# CITY OF ALBUQUERQUE

**Re: McMahon Shopping Center**  
**10550 Unser Blvd NW**  
**Traffic Circulation Layout**  
Architect's Stamp 07-20-2021 (A11-  
D017B)

Based upon the information provided in your submittal received 11-16-2021, the above referenced plan cannot be approved for Building Permit until the following comments are addressed:

PLAT OF
UNSER AND MCMAHON CENTER
WITHIN THE TOWN OF ALAMEDA GRANT
SECTION 2, TOWNSHIP 11 NORTH, RANGE 2 EAST, N.M.P.M.
CITY OF ALBUQUERQUE
BERNALILLO COUNTY, NEW MEXICO
SEPTEMBER 2021

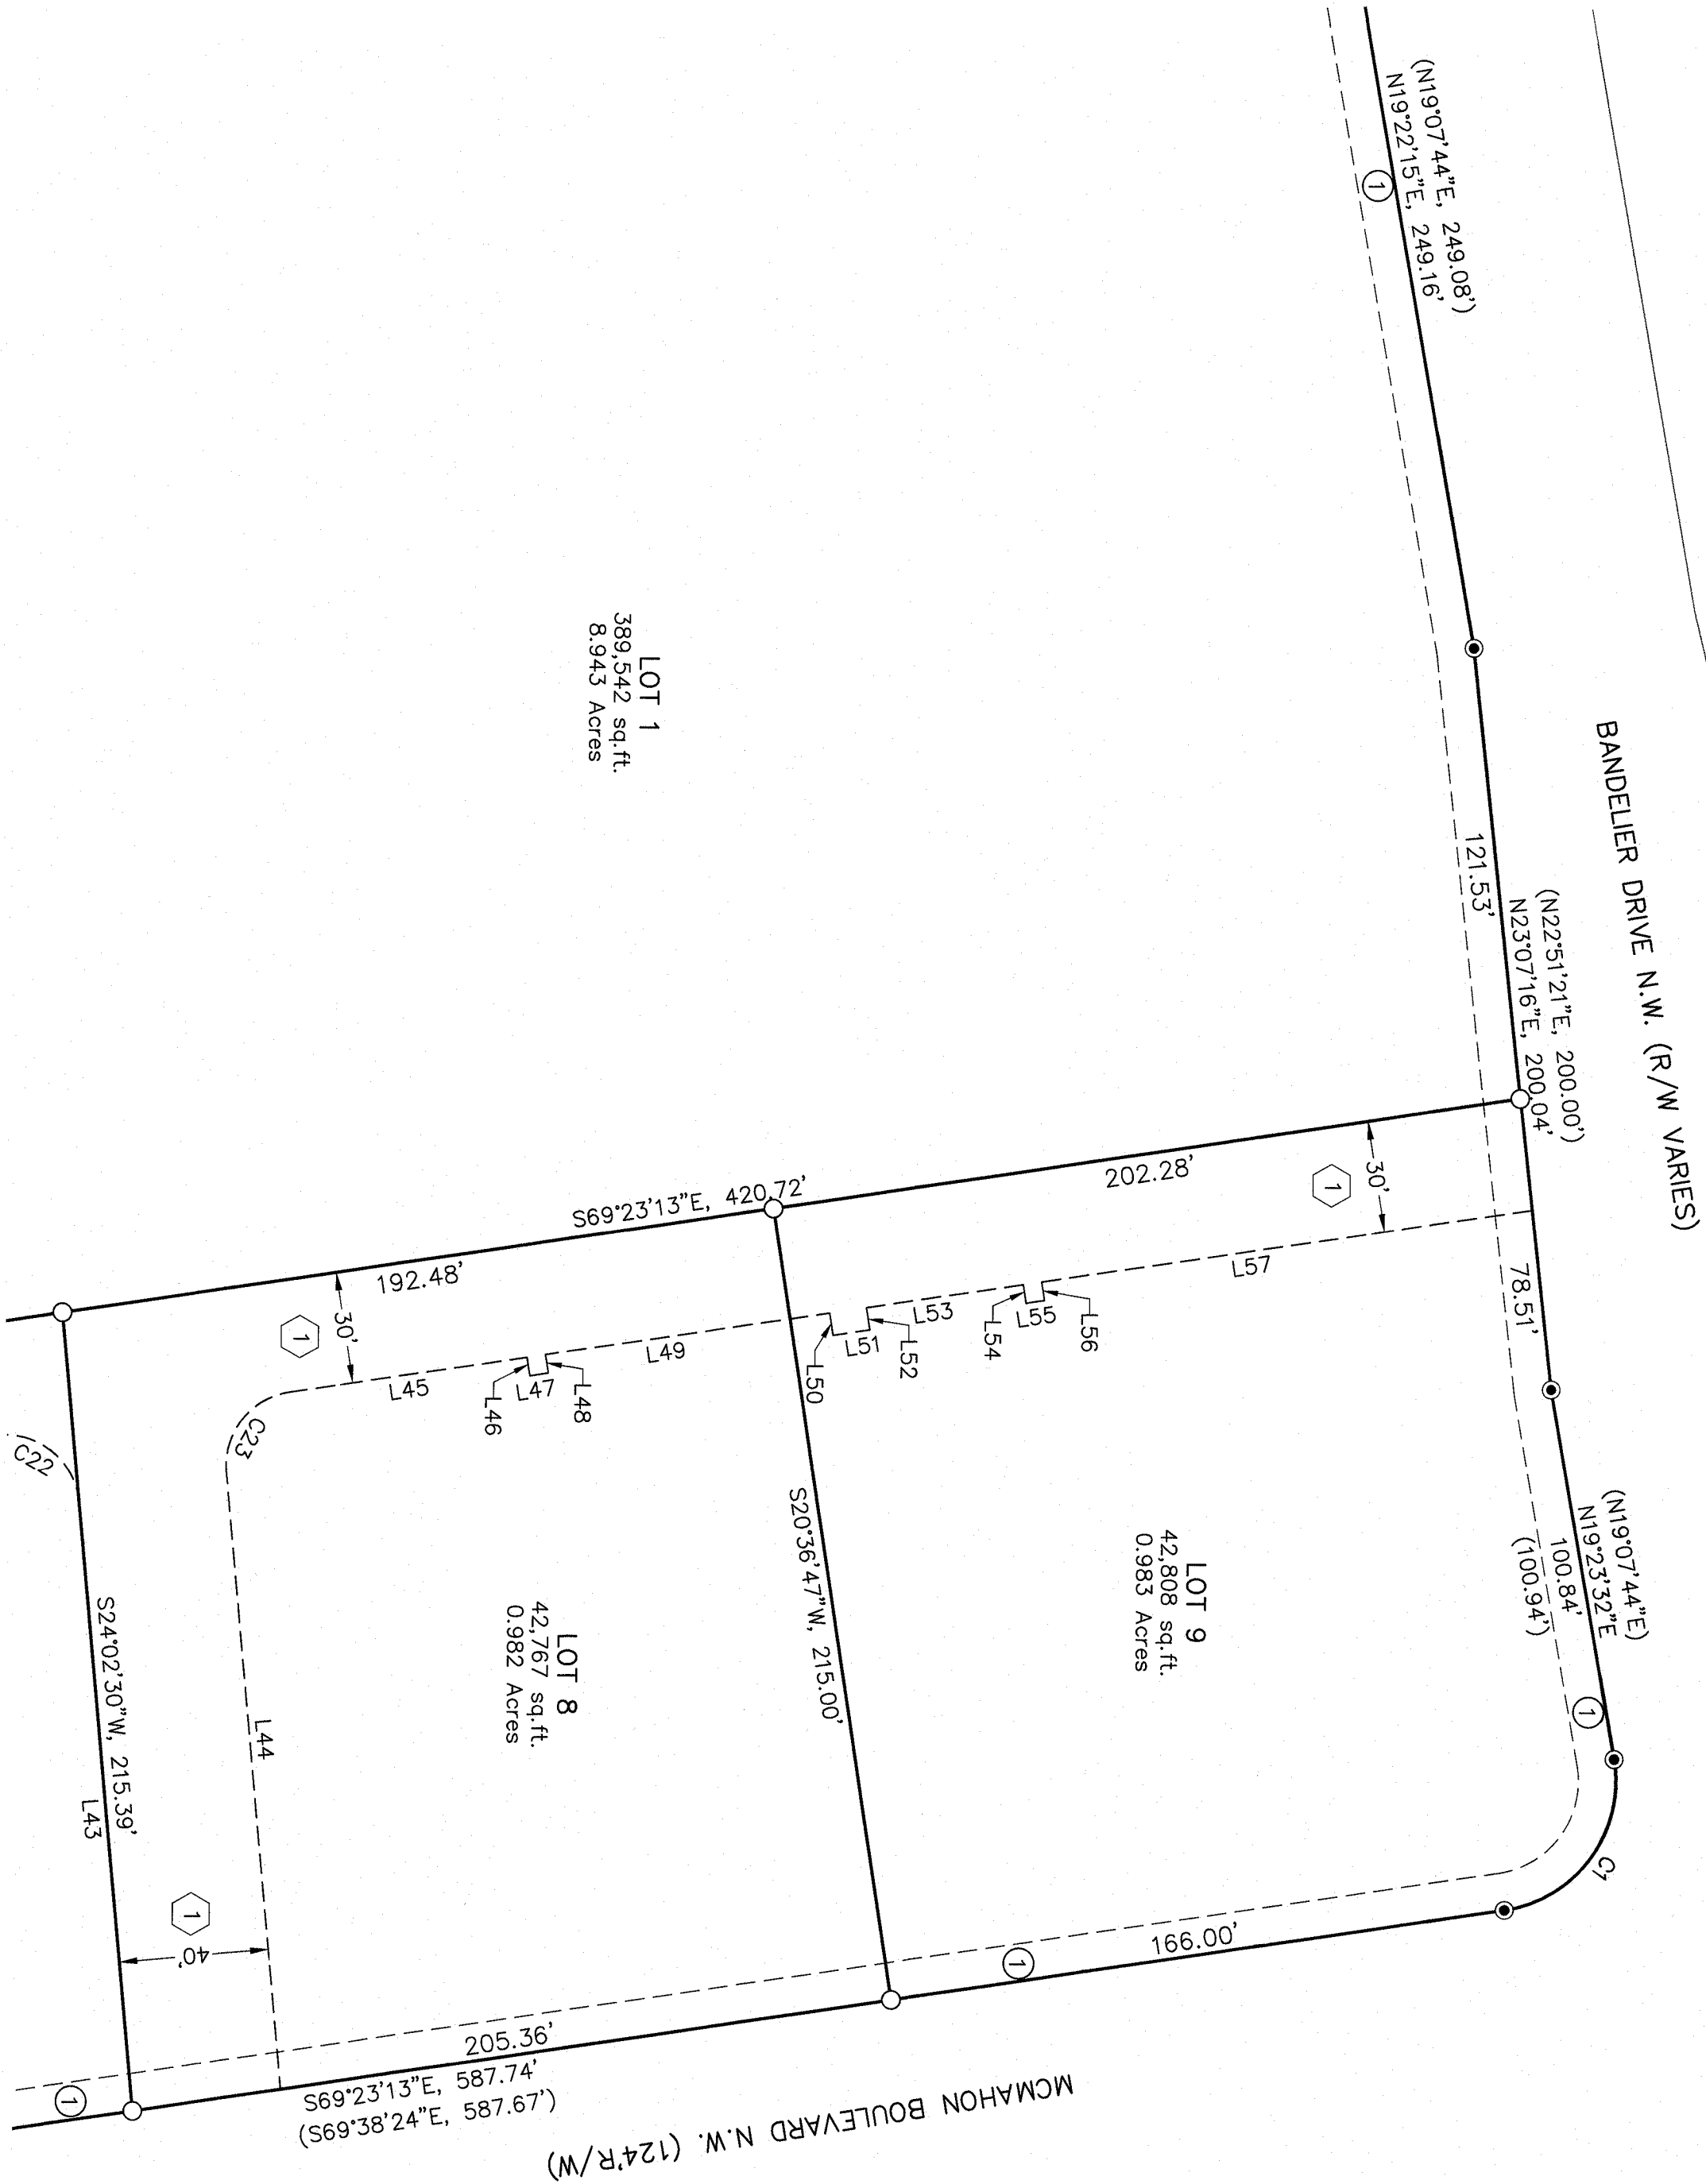
1. An approved PLAT will need to be provided to demonstrate plotted tracts/lots. **This includes all 7 sheets.** I will need these sheets to review all access/pedestrian easements being proposed on this TCL project.

- You will need adjacent land owner permission to have ramp or property. Of course, the Plat hopefully shows an easement for this encroachment and/or land owner agreement to have ramp located on their frontage.

UNSER & MCMAHON  
ENLARGED SITE PLAN  
ALBUQUERQUE, NM  
PROJECT #2063

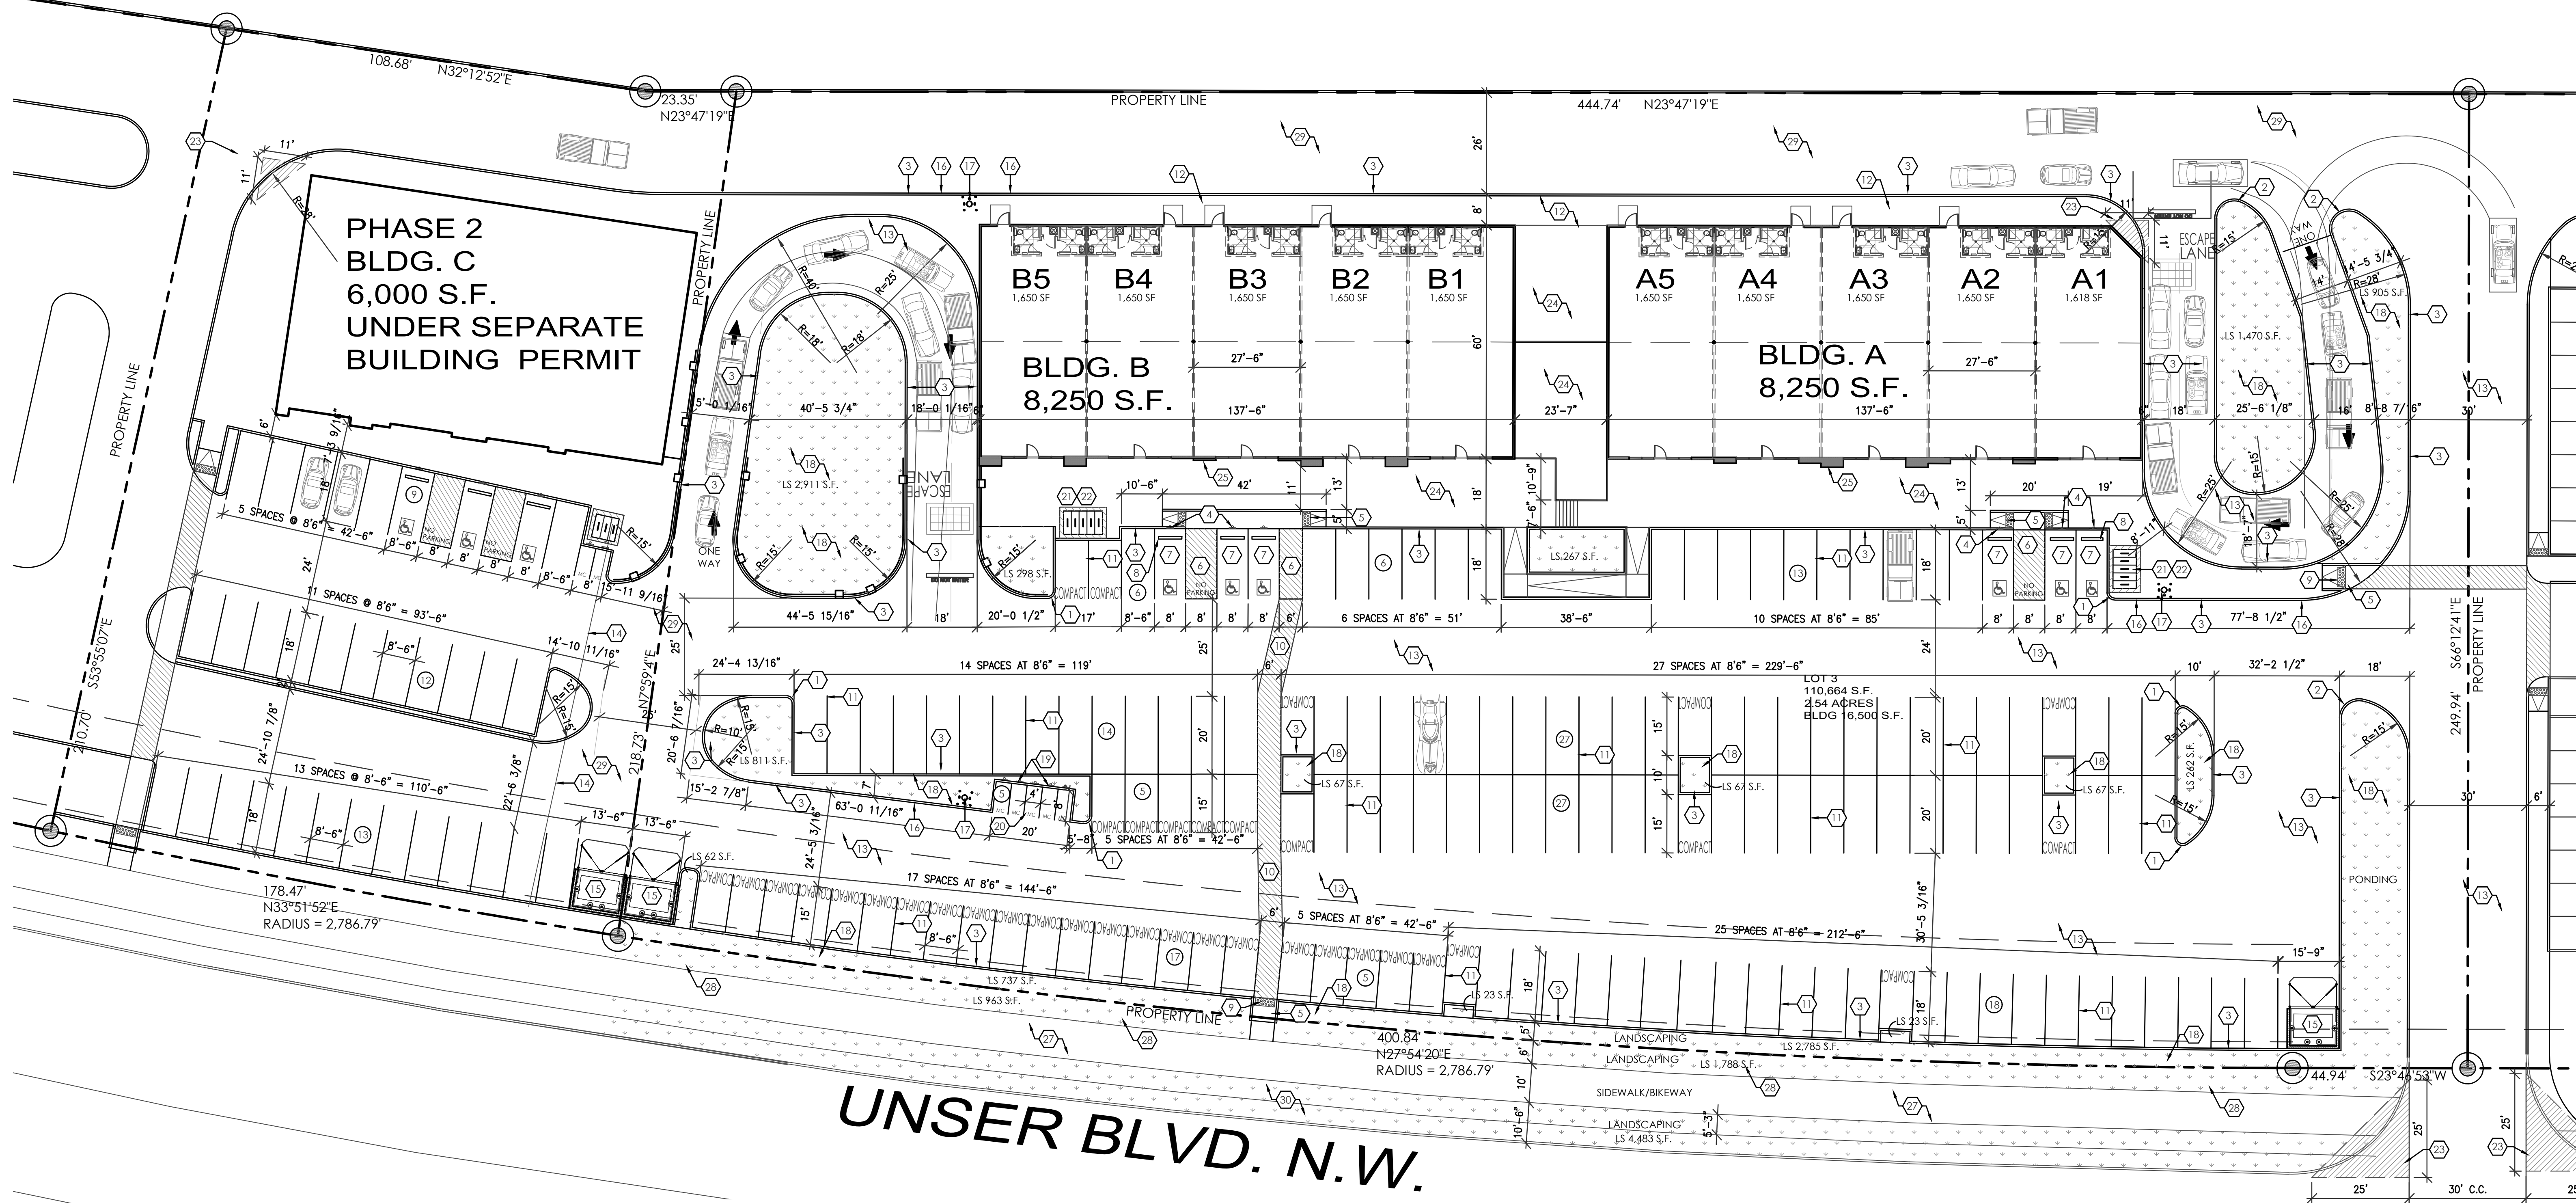
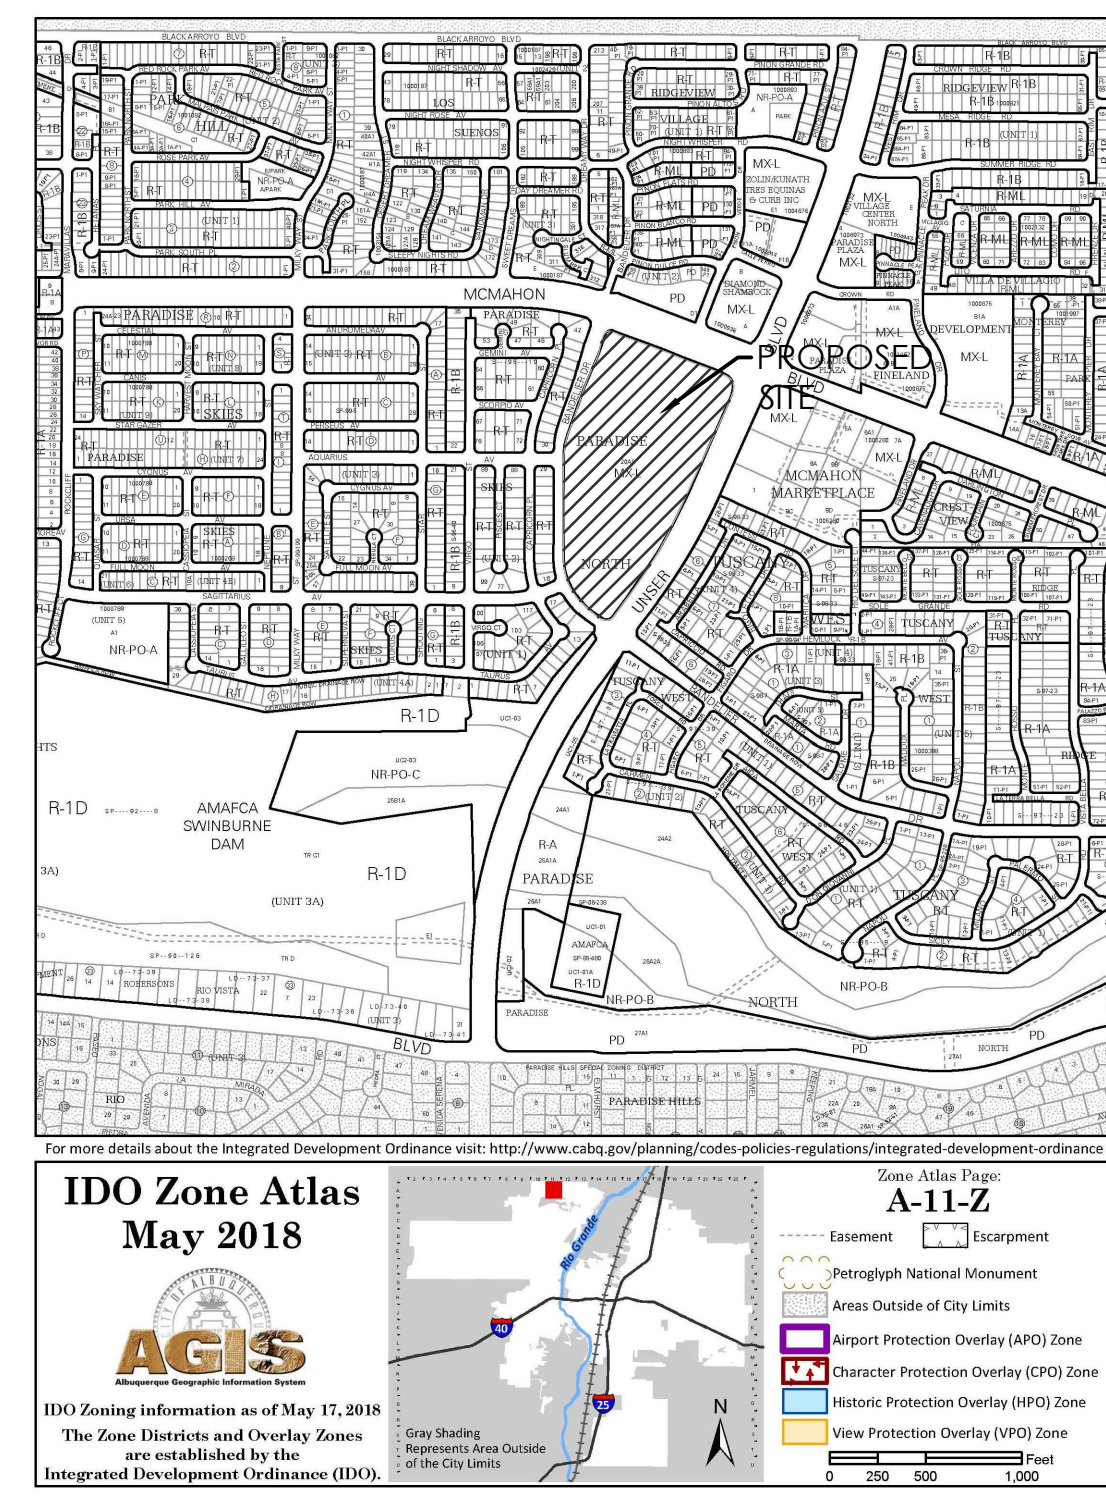
- Keyed Note 19 (Motorcycle Parking Sign): Provide sign face detail.
  - Keyed Note 30 & 31: Pavement marking detail will need to be provided.
  - Keyed Note 32 (Do Not Enter): Provide sign face detail.

4. Bldg A & B (proposed drive thru):
  - Details will be needed for sign face, pavements markings and striping at entrance/exit for drive thru lanes.

- All parking stalls will need to be 8'-6" in width instead of 8'.
- Bldg B: The third ADA access aisle/6 ft pedestrian pathway will need the "NO PARKING" pavement markings shown.
- Bldg A: the 2 proposed ADA parking stalls will need another 6 ft access aisle to service the last ADA stall.
- Bldg A & B: The two proposed ramps in front of Van accessible aisle will need a railing to avoid any type of tripping hazard with grade change.
- Proposed Planter (LS 267 SF) between Bldg A & B: Hand railing (design/follow per **ADA STANDARD for ACCESSIBLE DESIGN**) will need to be provided and details provide for each segment and width shown. The segments will include 5'x5' (2% max.) at each turn with 4 inch plate at bottom of each railing design.

- Ramp location will need to be shown on private property (all portions).
- Detail for ramp will need to be provided. Reference COA std dwg 2442.
- Curbing needs to be provided for the ADA 6 ft pedestrian pathway to shield pedestrian between Compact parking stalls.

7. Compact Parking (located behind Unser frontage): You have an offset of drive aisle width realignment.. Explain if this parking stall striping/overlapping onto drive aisle be a traffic safety concern? Provide a solution for this concern.
